Cowfold Rampion Responses to Local Impact Reports Deadline 2

Comments on REP1-044 Horsham District Council Local Impact Reports:

**Rampion 2 Offshore Wind Farm**  
 Figure 22.7a Waterbodies not surveyed due to limited access

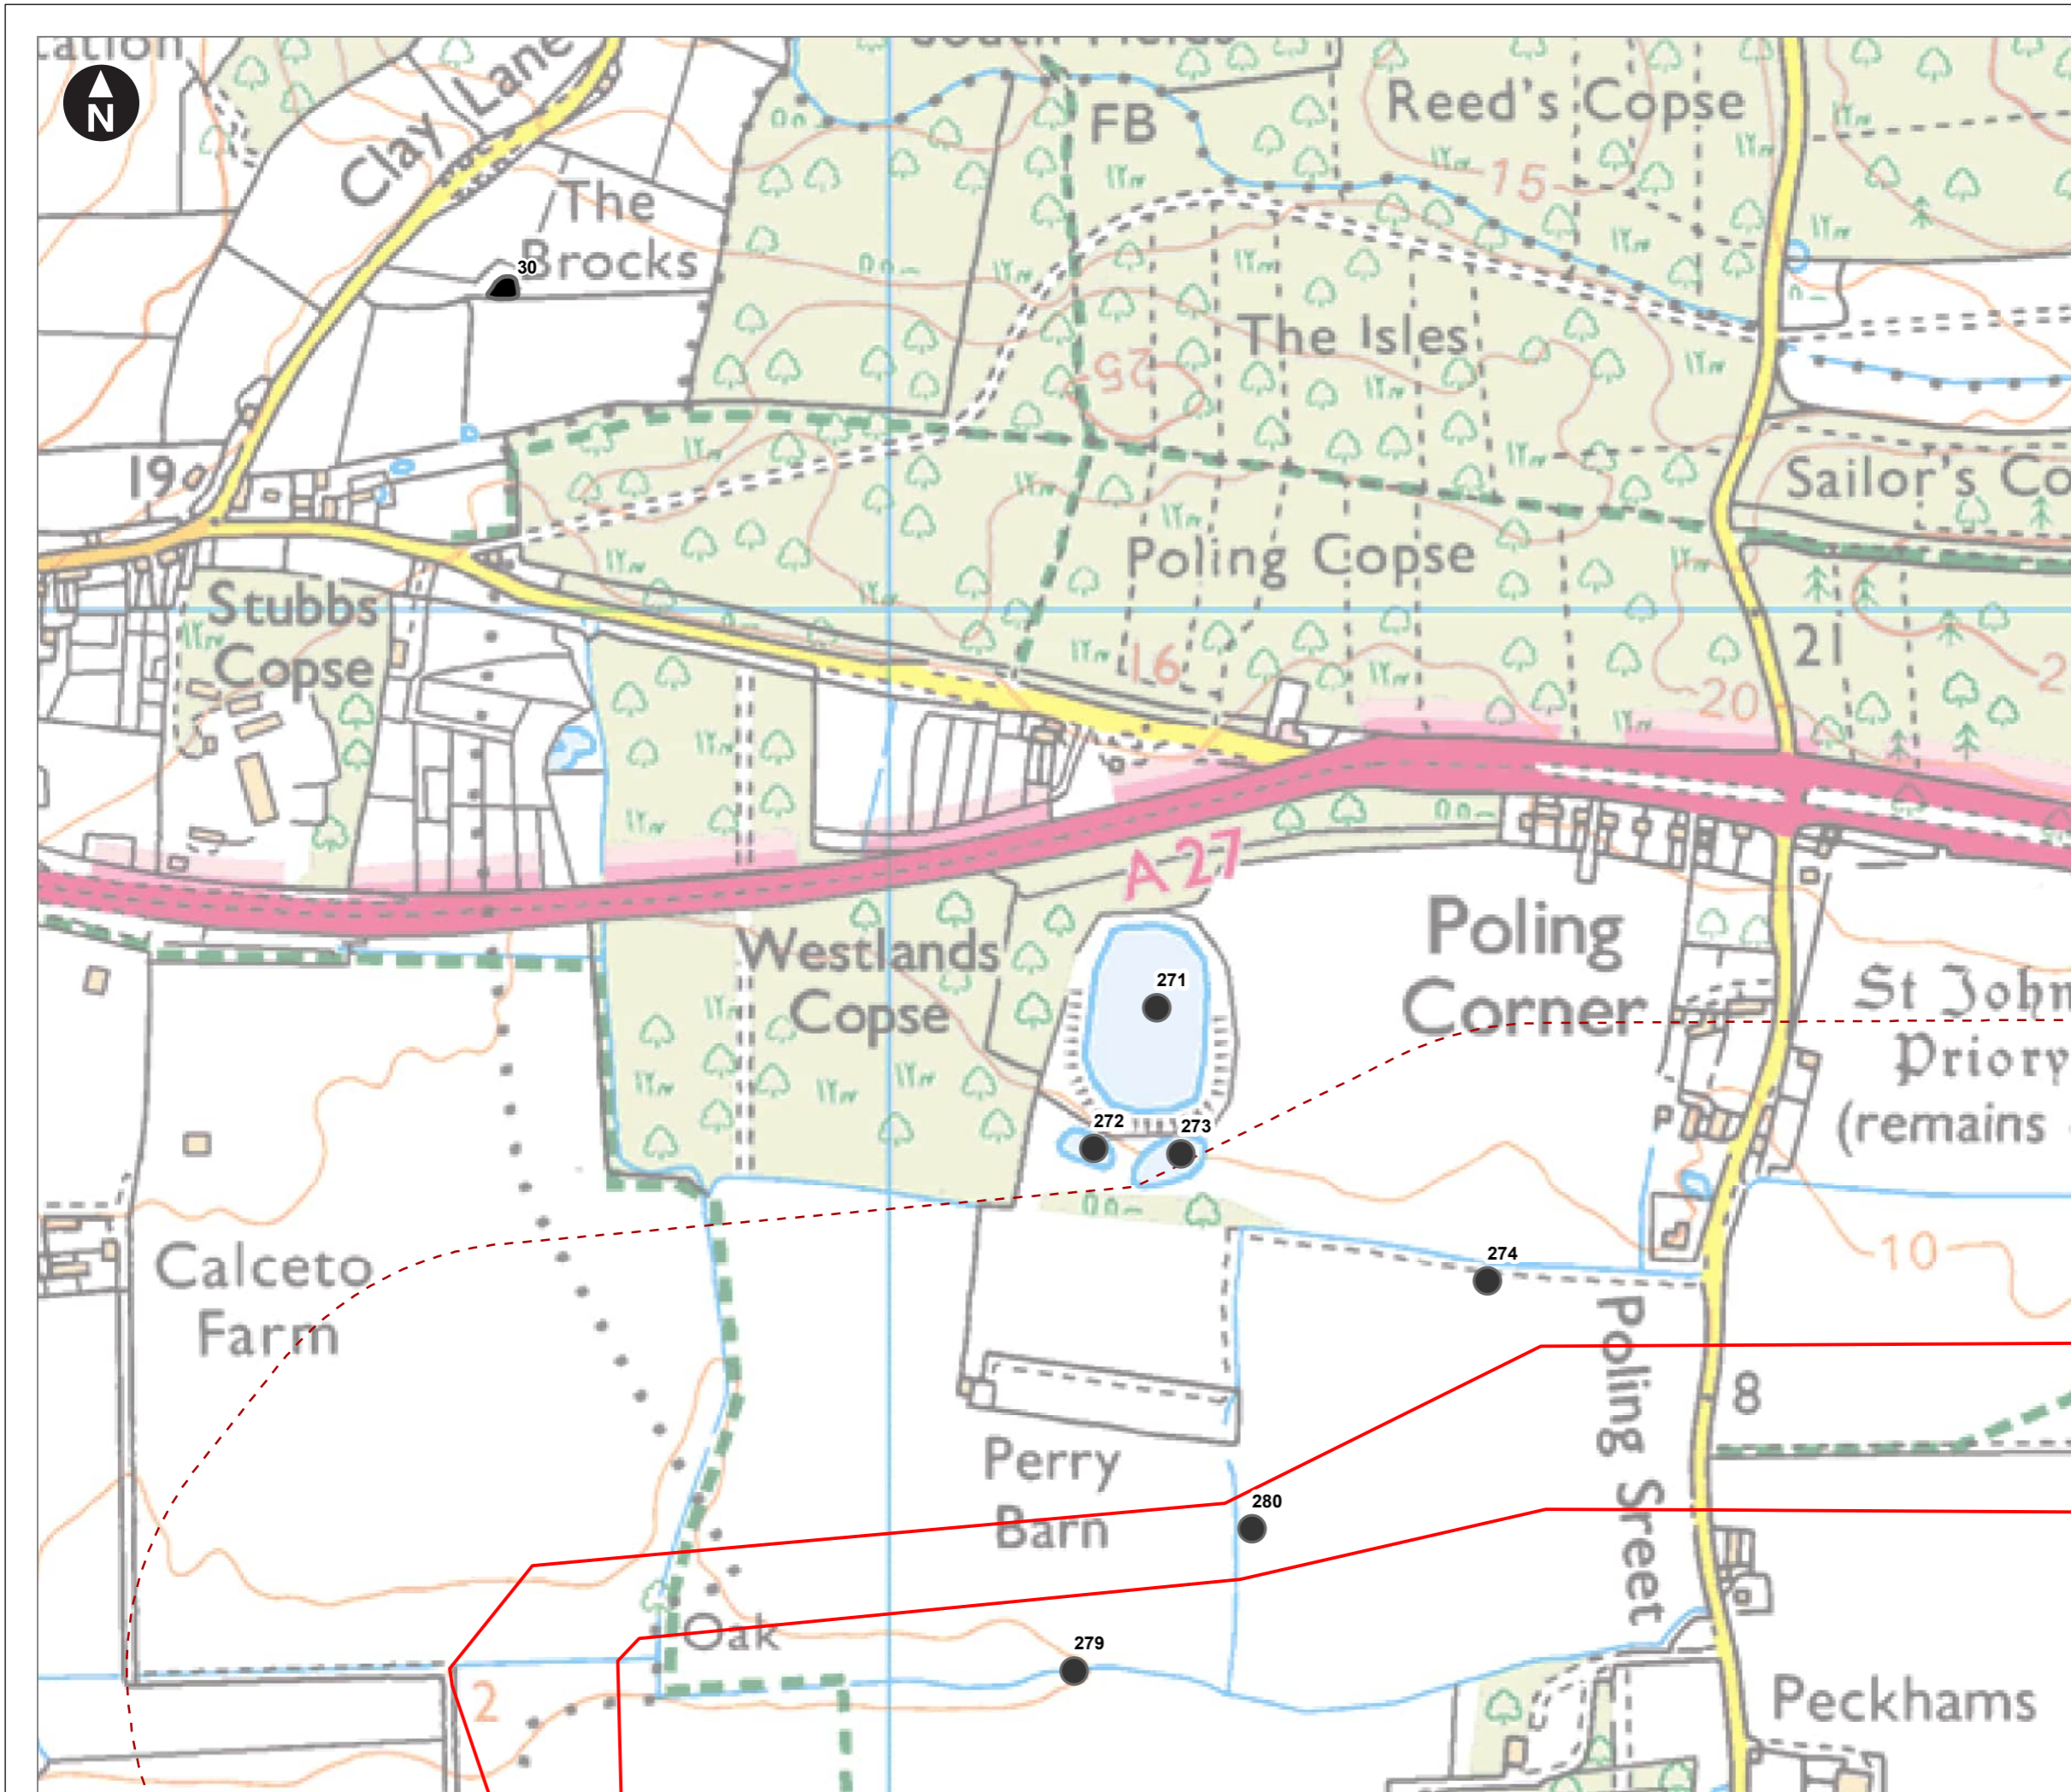
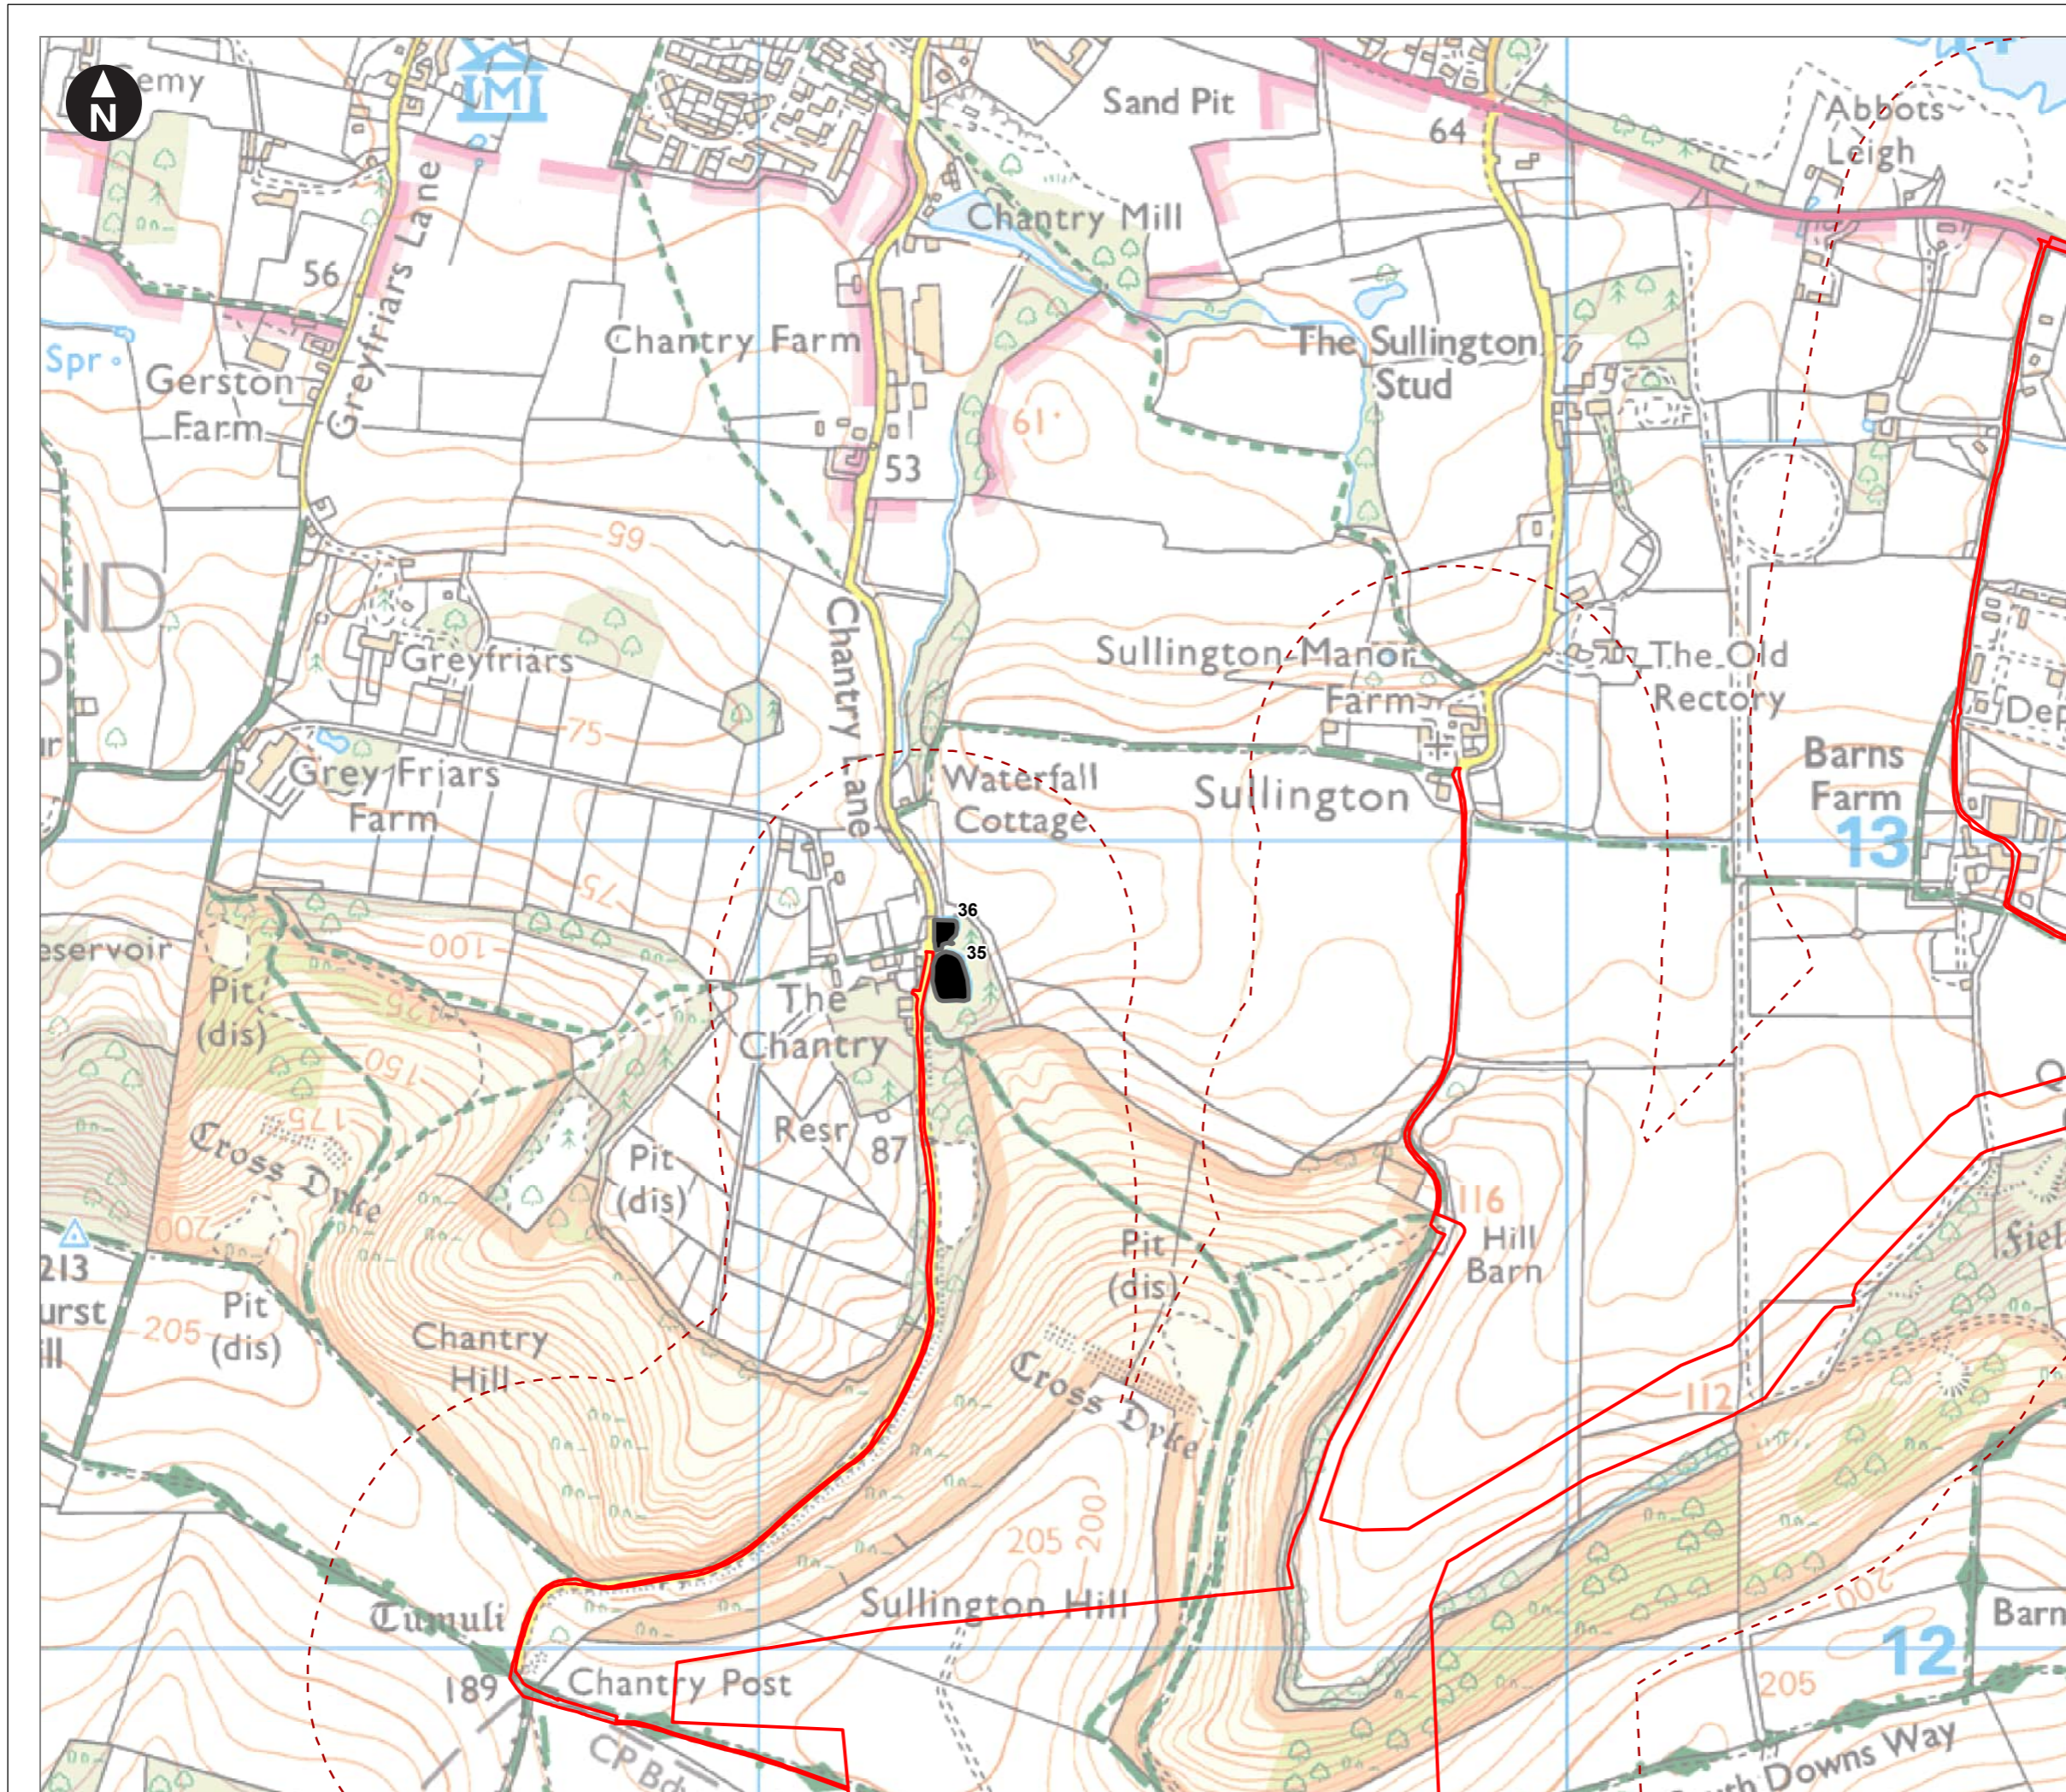
3.1) CowfoldvRampion endorses Horsham DC’s concerns but would like to add that the sites chosen for meadowland survey also do not reflect the most valuable meadowlands. The newt ponds and survey dates are already available; they show a high proportion of ponds in this area were either not surveyed as they were ‘inaccessible’, or were surveyed outside prime months, or DNA was degraded.
